Our ref: DOC20/881350

Senders ref: SSI-10051

Subject: EES comments on Environmental Impact Statement for Sydney Metro - Western Sydney Airport Project – SSI-10051 – St Marys to Western Sydney Aerotropolis Core precinct

SYDNEY METRO WESTERN SYDNEY AIRPORT					
SURFACE AND CIVIL ALIGNMENT WORKS					
CIVIL					
SCARW2540 SCAW SITE ACCESS AND HAUL ROADS PACKAGE #1					
LAYOUT PLAN					
FILE No:				SHEET: 1	OF 13
STATUS: FOR CONSTRUCTION				EDMS No:	
DRG No: SMWSASCA-CPU-SWD-EW150-RW-DRG-254111				REV 00	VER

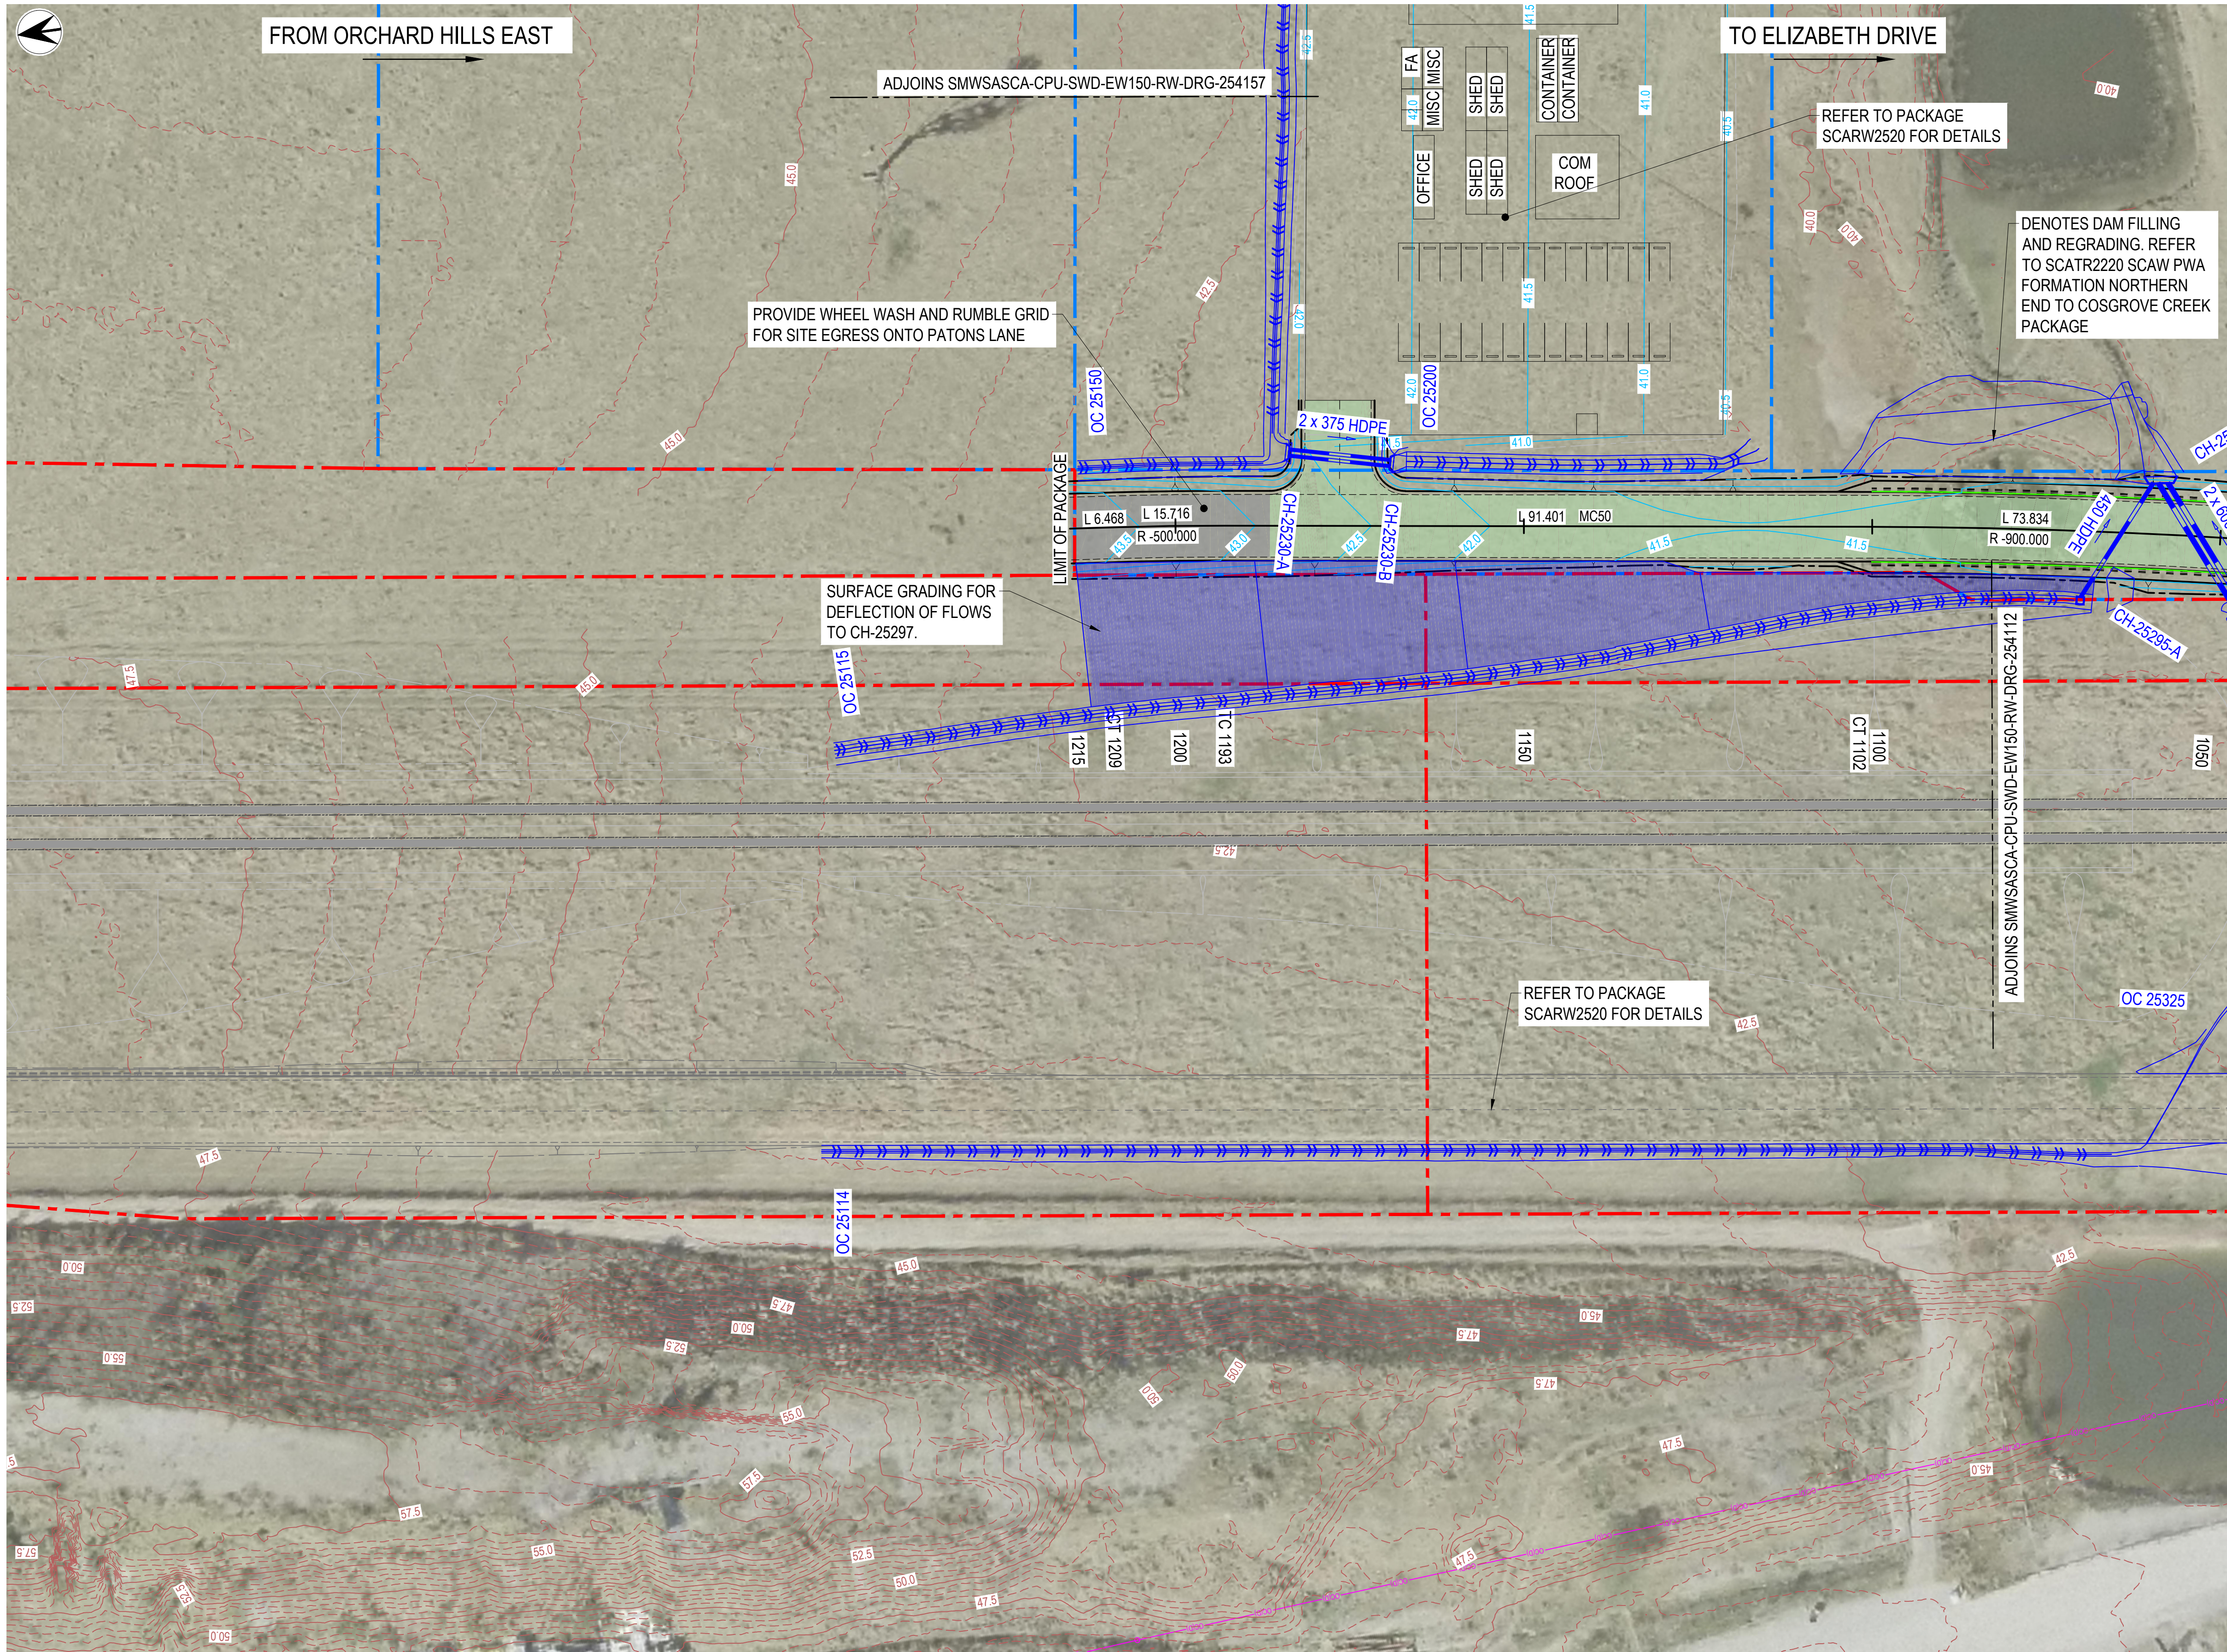
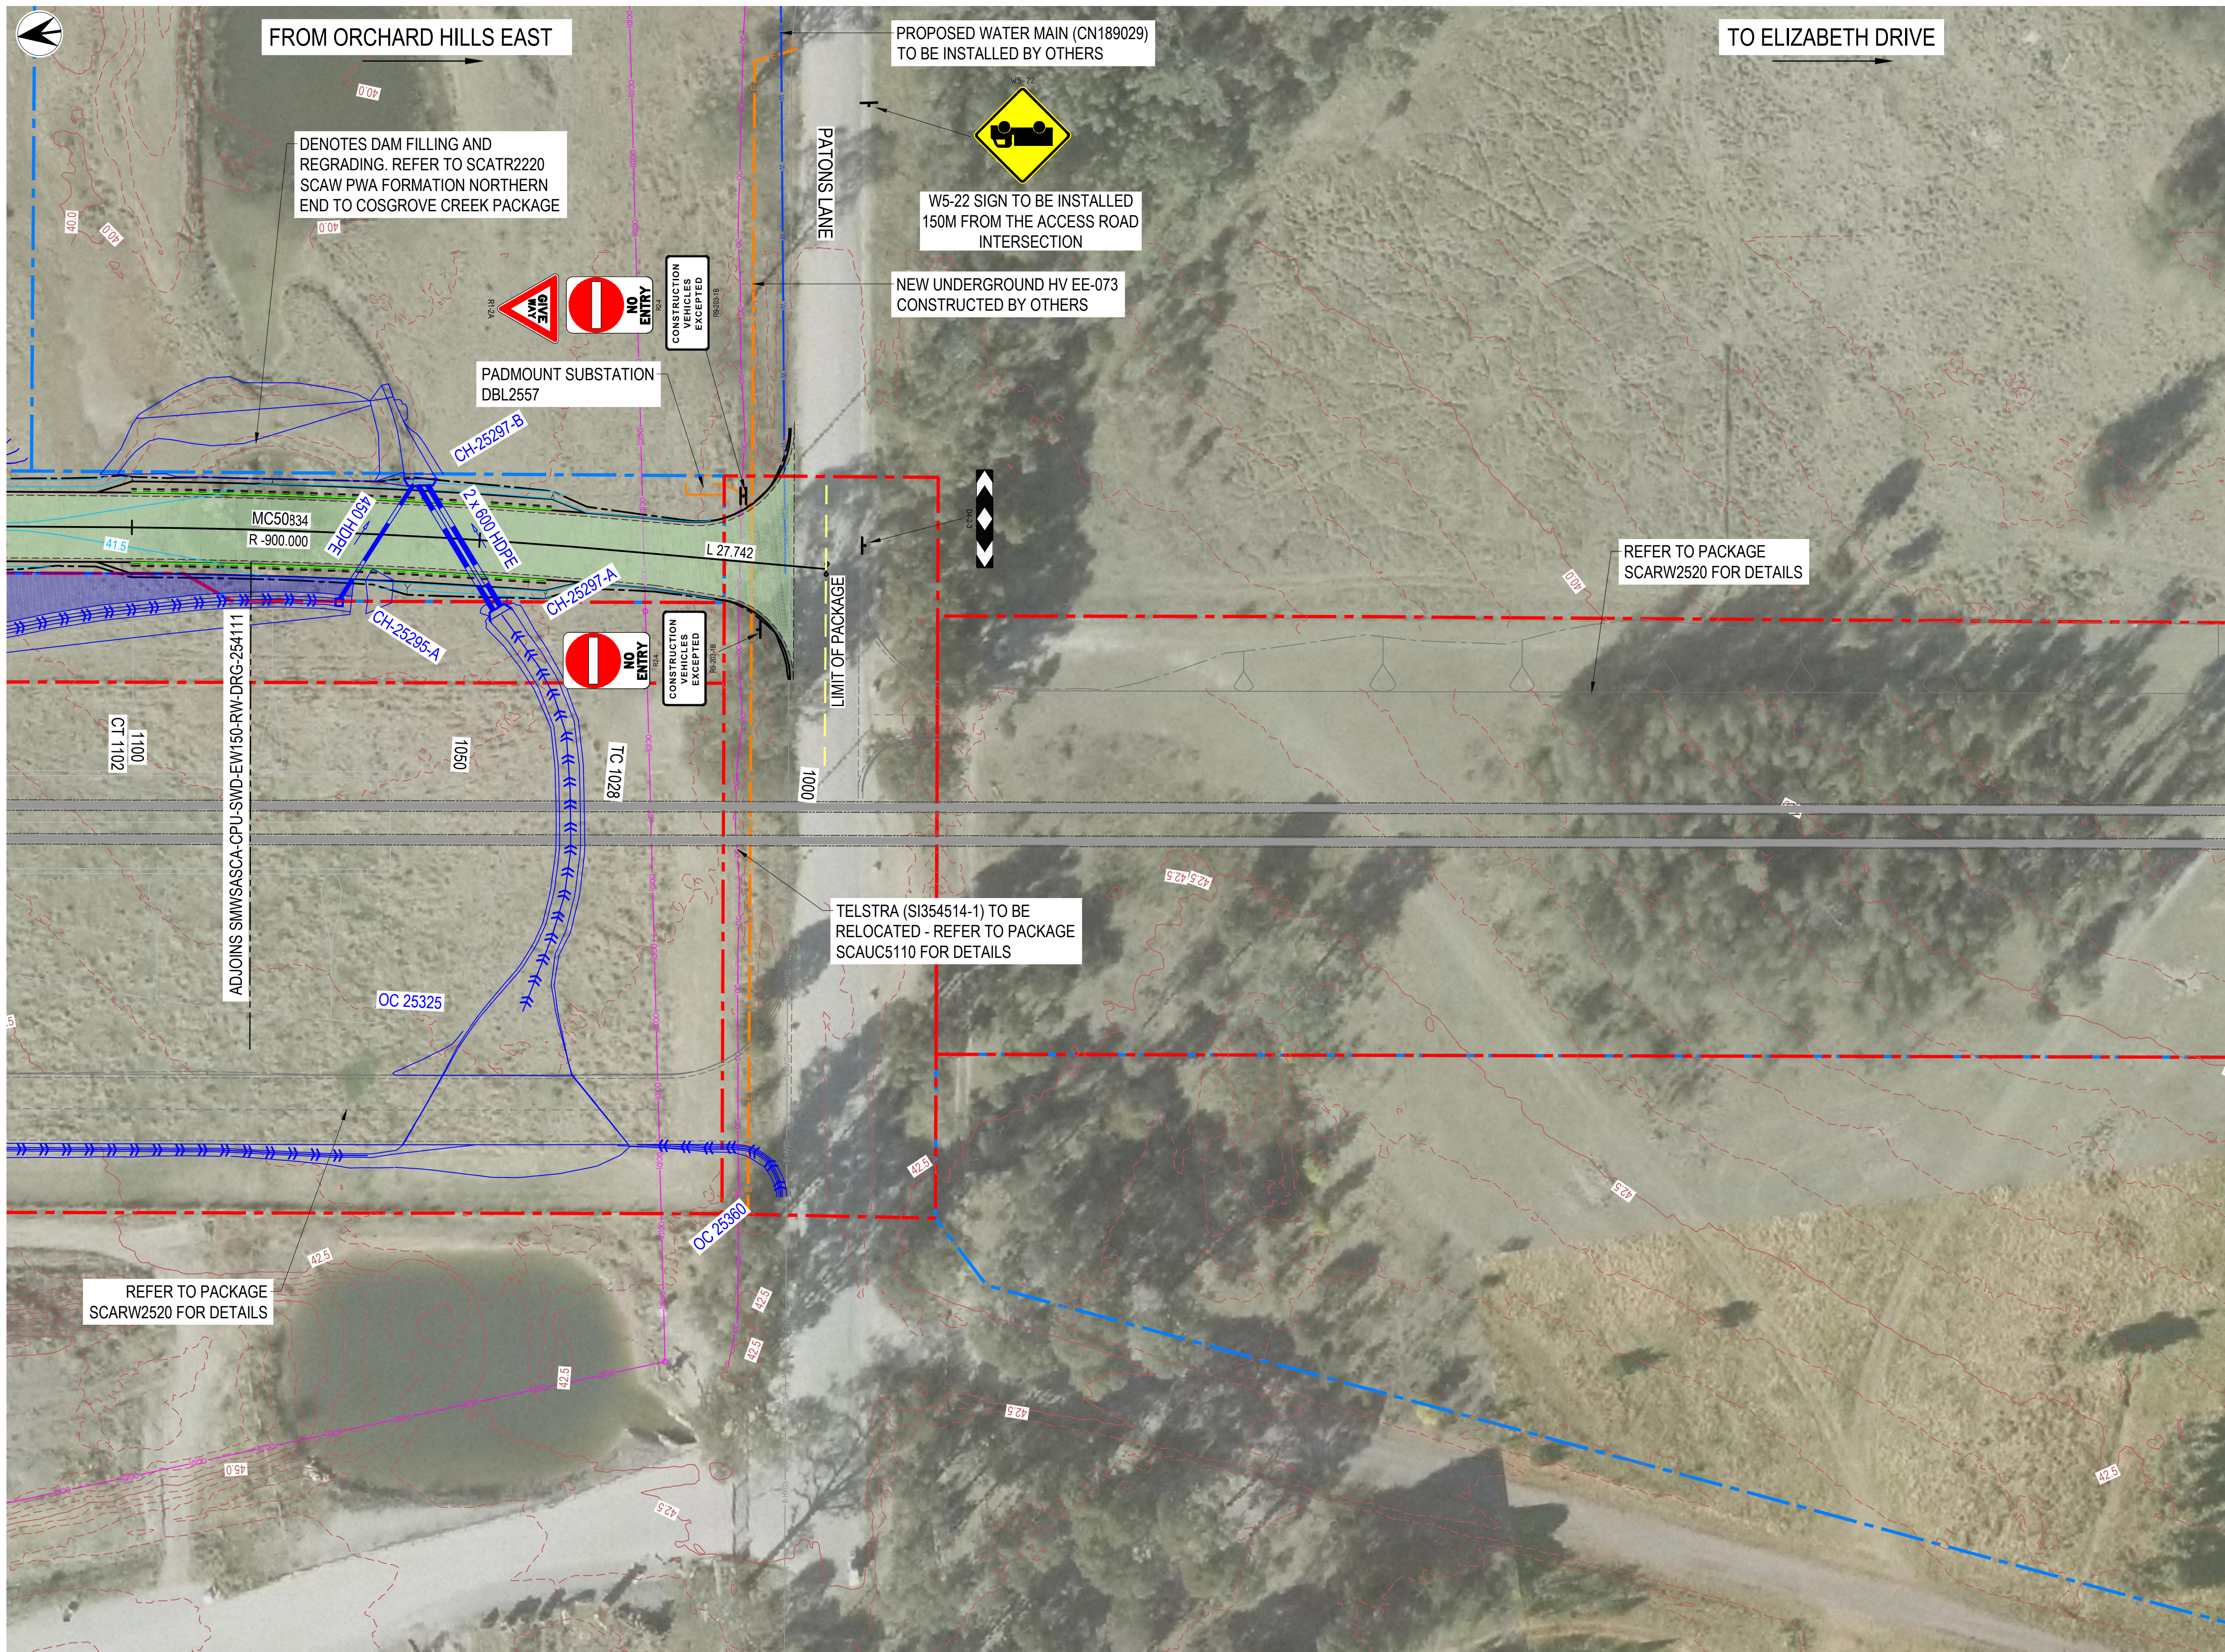
Figure 7.4b shows that part of the proposed bridge/viaduct near Patons Lane would be located over cleared land beside an existing quarry but the length of the bridge/viaduct does not extend to protect all of the existing remnant vegetation along the unnamed tributary of South Creek (see extract of figure below and red arrow).

The structure should preferably be longer in length and/or located to protect all the remnant vegetation. The bridge/viaduct structure should minimise the clearing/disturbance of existing native vegetation, maintain and/or improve connectivity under the structure to maximise the corridor function. It should be elevated and span the full width of the corridor and/or remnant native vegetation which-ever is the widest to avoid or reduce the need to clear and/or disturb remnant native vegetation. The RtS should provide further details on this.

Figures 7.4b and 7.4c show the proposed bridge/viaduct crossings of Cosgroves Creek and the unnamed tributary of South Creek do not completely span the remnant vegetation along the creeks. EES recommends the bridge/viaduct completely spans the full width of the riparian corridor/remnant native vegetation on both sides of these creeks.
